**KIRKLEES COUNCIL
TOWN AND COUNTRY PLANNING ACT 1990
HIGHWAYS DEVELOPMENT MANAGEMENT**

PLANNING REF 2017/62/90620/W0/MW
CATEGORY Small Major

PROPOSAL DEMOLITION OF EXISTING BUILDINGS, CHANGE OF USE OF EXISTING BUILDING TO MIXED USES COMPRISING B1A, B1C, A3, C3 AND OUTLINE PERMISSION FOR ERECTION OF 75 DWELLINGS

LOCATION DOBROYD MILLS
HEPWORTH ROAD
NEW MILL
HOLMFIRTH
HD9 1AF

Drawing 2009-2009 - Rev A
Indicative Site Sections for the
residential and mixed use
redevelopment of
Dobroyd Mills,
Hepworth / Jackson Bridge

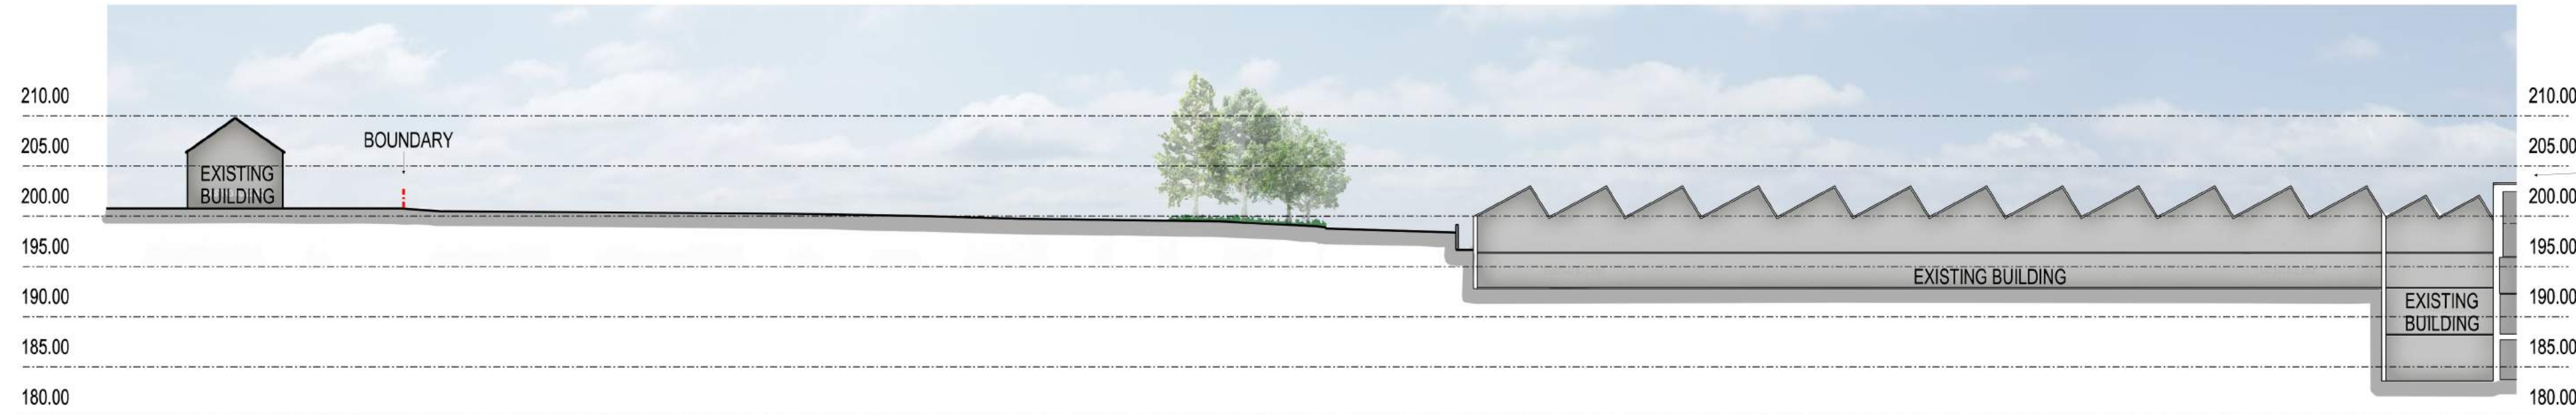
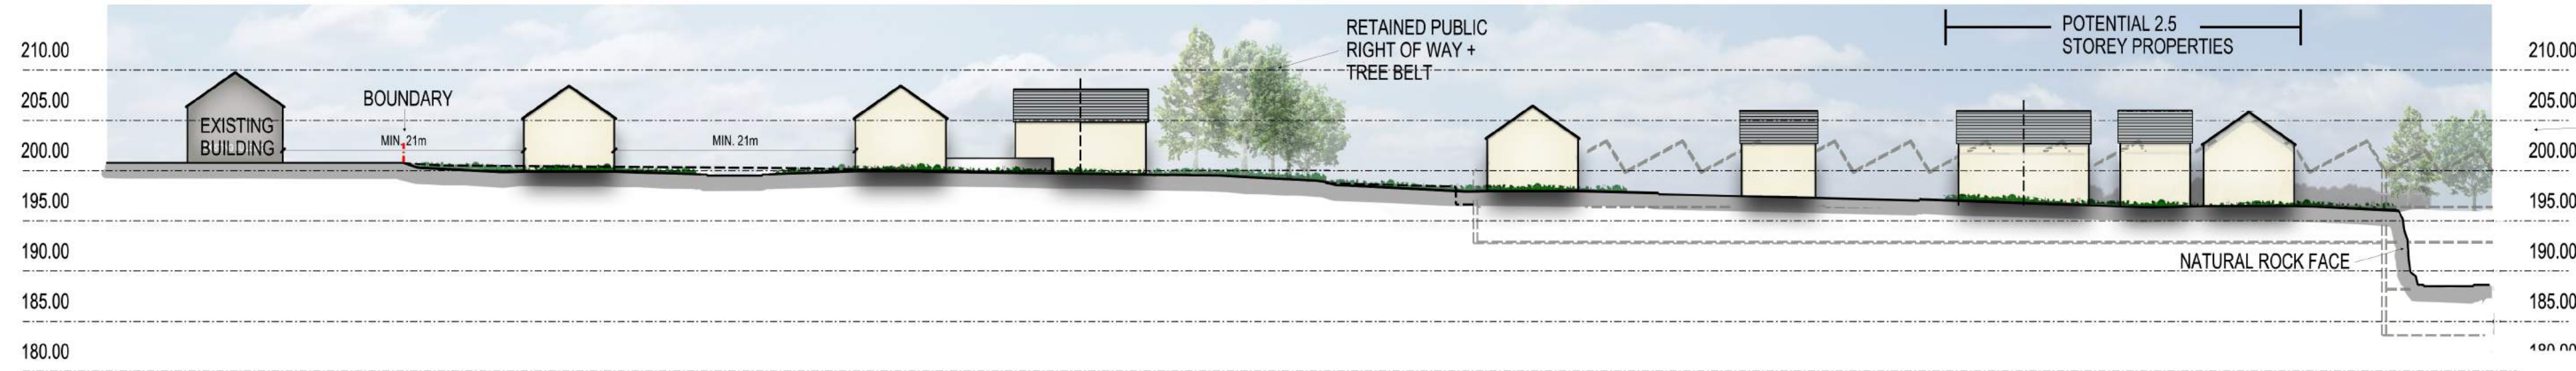
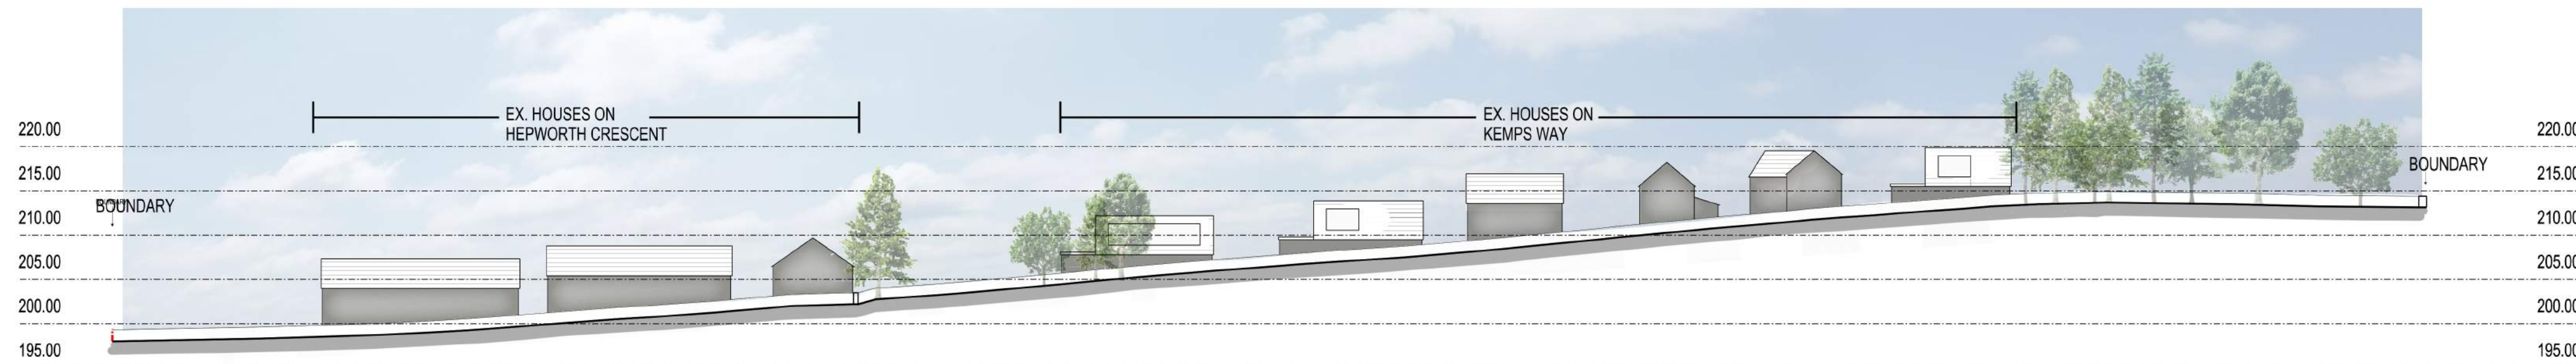
The longitudinal sections show gradients of between 1 in 14 and 1 in 16 along the length of the road with a 20 metre level platform noted as a vertical curve. These gradients should be acceptable.
